Re Planning Application No: 3/2023/0058.

Unauthorised Timber Fence to rear garage roof at 5 Whalley Road, Read. BB12 7PB.

REAR ELEVATION - 1:100 at A3

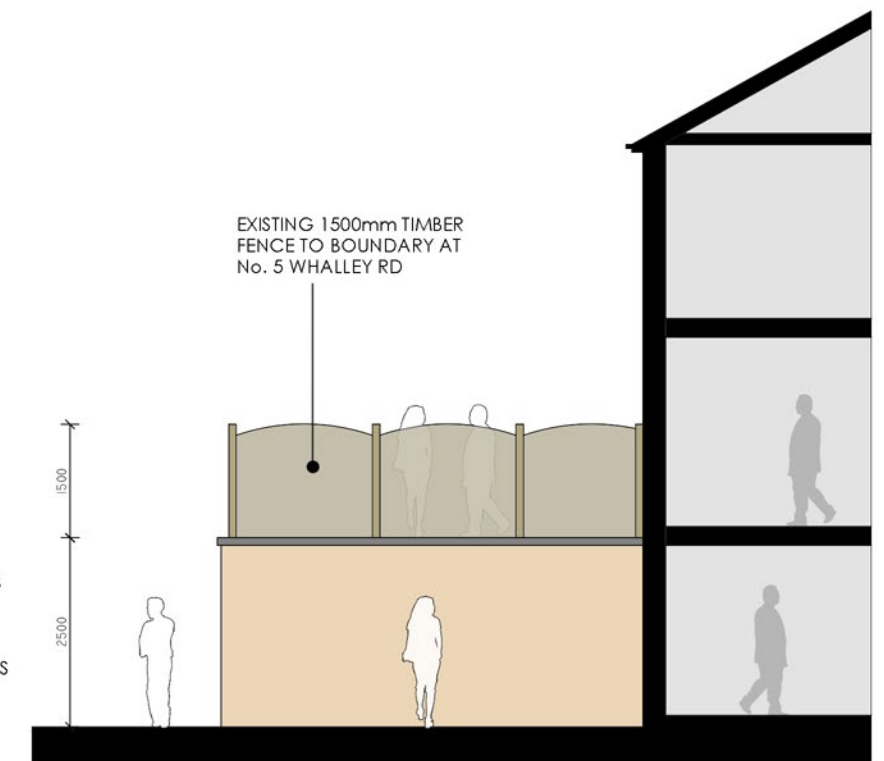
The Architects Plans submitted with the proposal are incorrect and misleading giving a false impression of the garage and fence being lower against the  when it is in fact much higher as to obscure the
